May 13, 2019

**Reference: Kanata North – CU Developments Inc.
Draft Plan of Subdivision and Zoning By-law Amendment Applications
Planning Rationale Addendum
City File Nos.: D02-02-18-0076 & D07-16-18-0023
Our File No.: 116132**

This addendum responds to the CEPEO's and the City's request for revisions to the Planning Rationale to address their respective comments.

Figure 11: Proposed Draft Plan

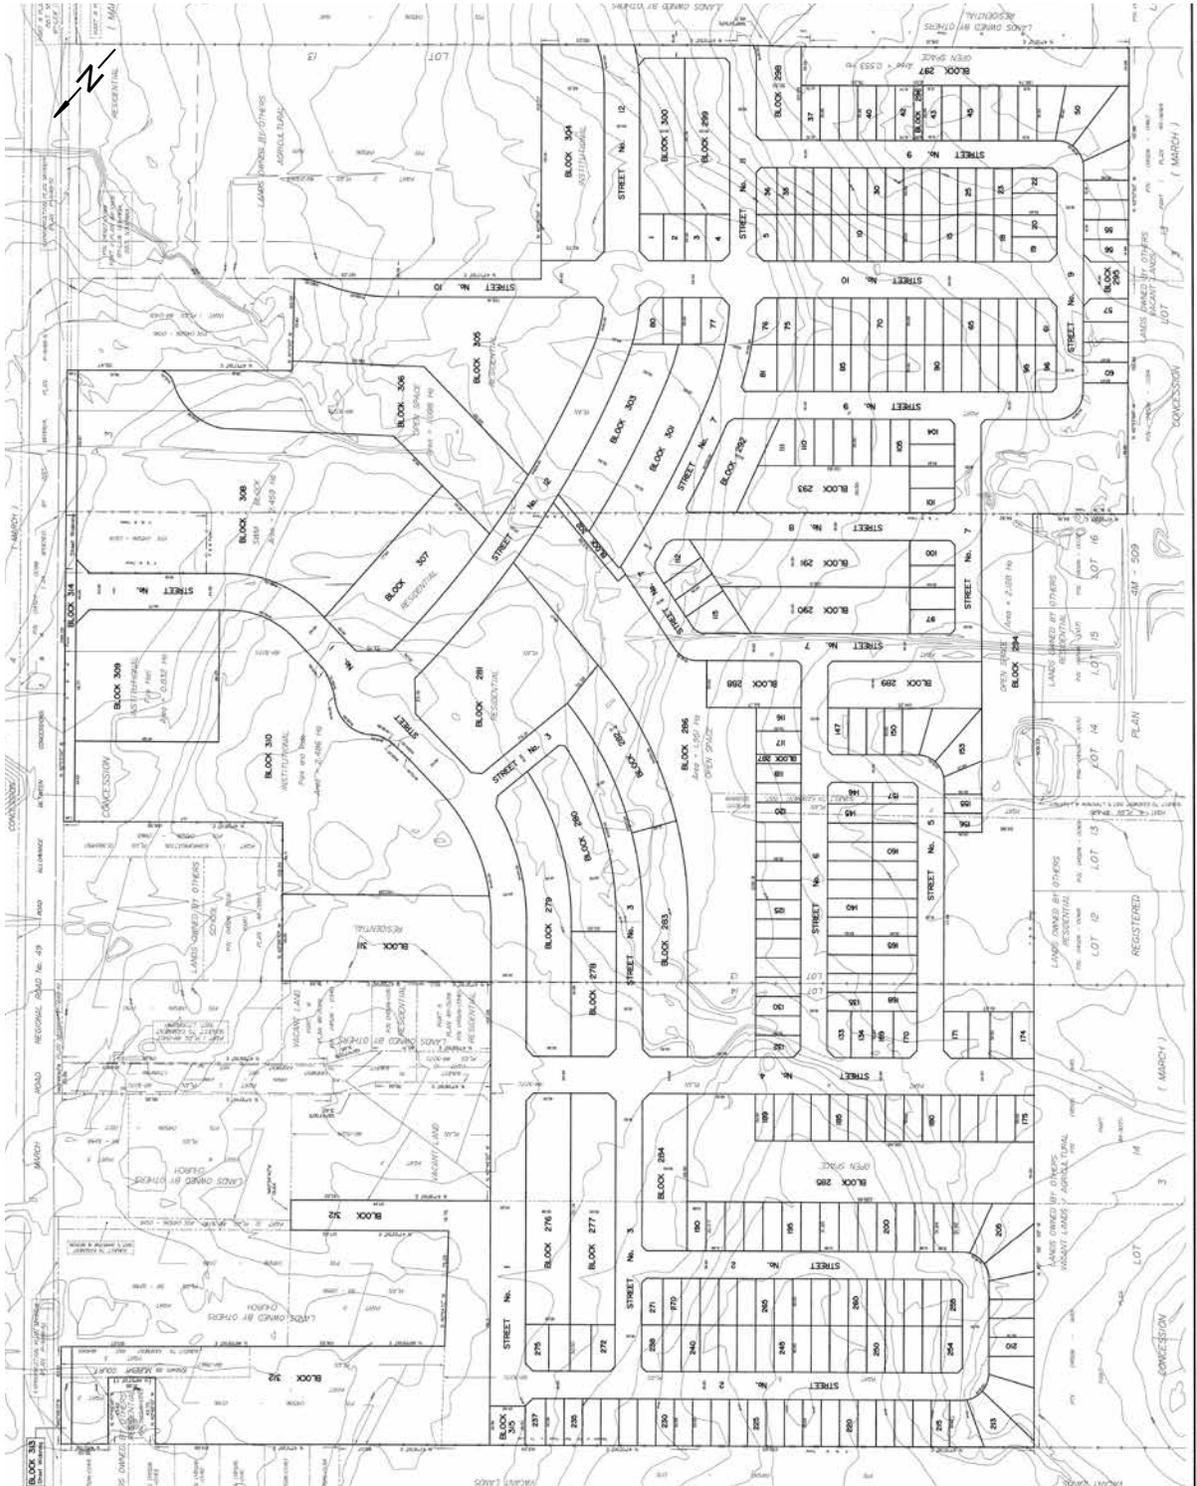
Please include a chart in the planning rationale comparing how much land has been added to the Shirley's Brook corridor (block 285 and 286) and Block 297 vs what was proposed for the retained natural feature abutting Woodlot S-12 in the CDP demonstration plan. Subject to a minimum net-zero change in the total amount of space preserved, an OPA will not be required to remove the Urban Natural Features designation from Schedule B.

The CEPEO site part located on block 304 is to be zone as I1A, Institutional. This zoning doesn't meet the CEPEO requirement for a secondary school site, as done on our other site in the city located at 2405 Mer Bleue (IA1[2530]/R3Z), we would like to propose the following changes with a few additional land uses:

The following table provides a comparison of the Open Space area attributed to natural features in CU Development Inc.'s (CUD) lands in the Kanata North Community Design Plan (CDP) Demonstration Plan (2016) and CUD's Draft Plan of subdivision (see Appendix 1 for an area comparison figure):

CDP Demonstration Plan	CUD Draft Plan
Tributary #2	Block 285	1.03ha	1.03ha
	Block 286	1.79ha	1.73ha
	Block 306	0.88ha	0.93ha
Tributary #3 (Block 297)		0.50ha	0.55ha
Subtotal		4.20ha	4.24ha
Open Space/Natural Feature abutting Woodlot S-12		0.18ha	0.00ha
Total Area		4.38ha	4.24ha

As noted in the area comparison table, there is a 0.14ha area difference between the open space provided for natural features in the CDP Demonstration Plan and the CUD Draft Plan. However, at the time the CDP Demonstration Plan was created, the stand of trees in the southwest corner of the subdivision lands was still linked to Woodlot S-12, thereby justifying its protection as a natural feature. As stated in Section 4.2 of the Planning Rationale, the forested area that linked the stand of trees in the subdivision lands to Woodlot S-12 was completely cleared by the abutting landowner after the Demonstration Plan was approved (see Figures 14 and 15 in the Planning Rationale). The Environmental Impact Statement/Tree Conservation Report (dated June 2018) therefore concluded that there is no longer ecological value in preserving the stand of trees in the subdivision lands.

Since the southwest tree stand is no longer linked to Wood-lot S-12, it should no longer be considered natural feature that must be protected. Tributaries 2 and 3 are still natural features and the CUD Draft Plan provides 0.4ha more of open space along them than what was shown in the CDP Demonstration Plan, as indicated by the subtotal in the table above.

Table 3 – *Proposed Zoning Schedule* in Section 2.2 of the Planning Rationale is amended as follows to revise the proposed zone for the CEPEO school block from Rural Countryside (RU) to Minor Institutional Subzone A – Exception XXXX, Height Limit 20 metres /Residential Third Density, Subzone Z (I1A[XXXX]H(20)/R3Z) per the CEPEO’s comment:
